Laurclavagh Renewable Energy Development Response to ACP FI reply from MKPO, Galway

Planning Reference: 319307

Date for Submission: 9th January 2026

Response to Further Information Laurclavagh Renewable Energy Development

Figure FI 3 N83 / L61461 / L61461 junction with STOP line re-located to nearside of hard shoulder

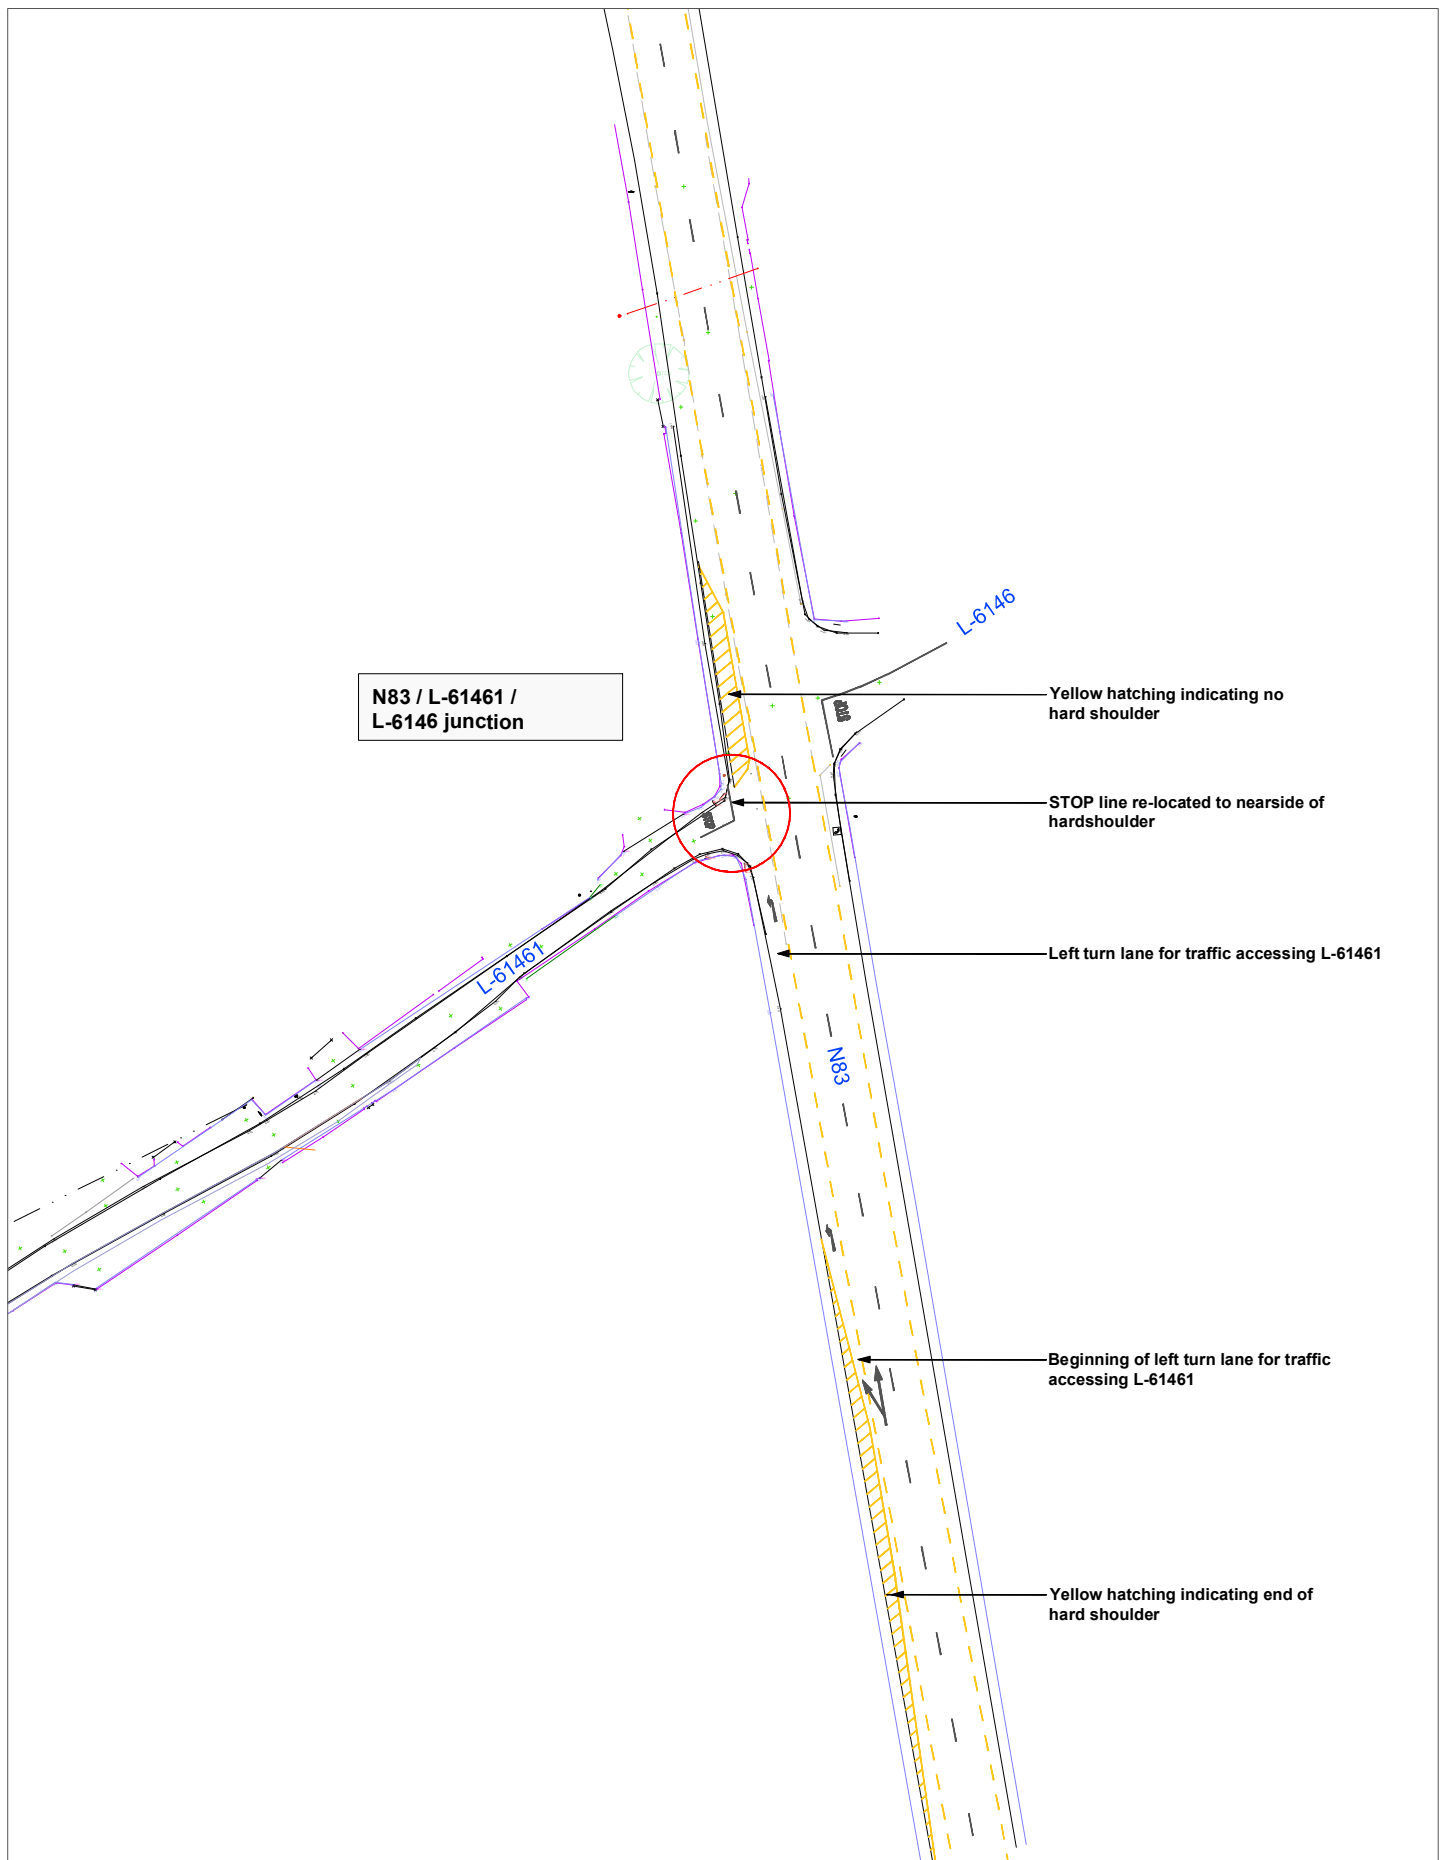
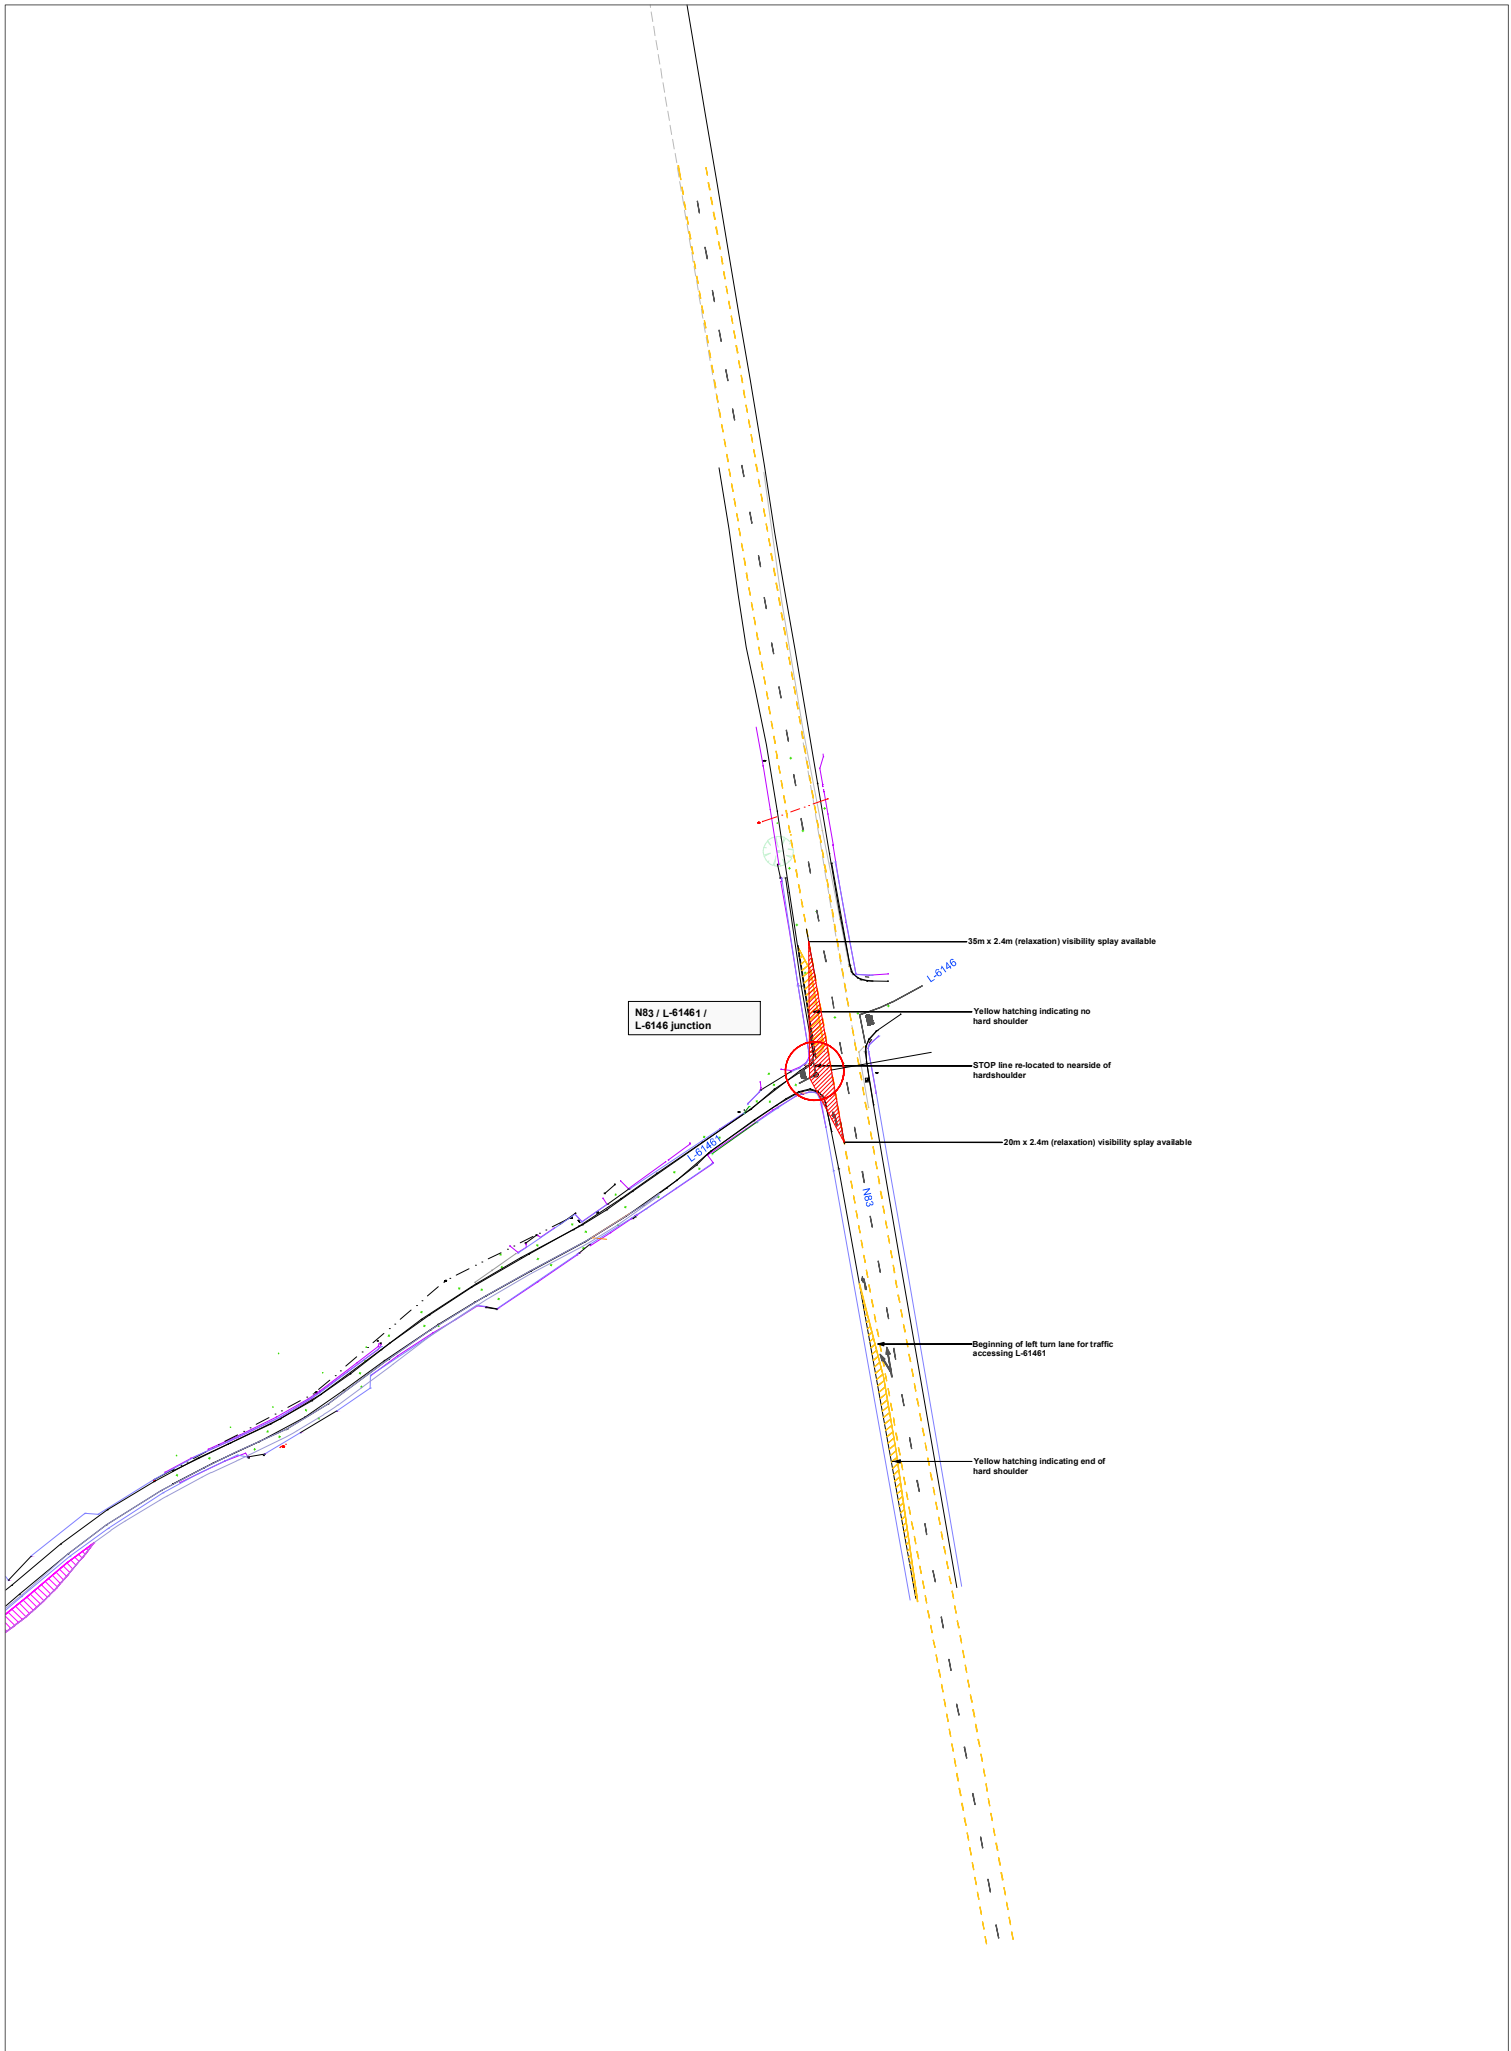
Note that the X distance should be 3m – 9m for Stop line control and not 2.4m. This crossroad is not a simple junction & no request for a relaxation from TII is indicated for a 2.4m X distance. This 3m minimum requirement reduces the Sight Distance Triangle to a lot lower than 35m & 20m. This is obviously why the Road Safety Auditor omitted mention of the junction issues. These SDT distances constitute a hazard to all traffic with rere-end shunts, head-on collisions and side-swipe accidents. It would constitute gross negligence to grant Planning Approval for such a proposal.

Note this photograph of 26/11/2025 shows Stop line at inside of carriageway edge from L-61461 on Western side of N83 facing Galway. There is no Sight Distance Triangle compliance of 215m @ 3m from this Stop line.
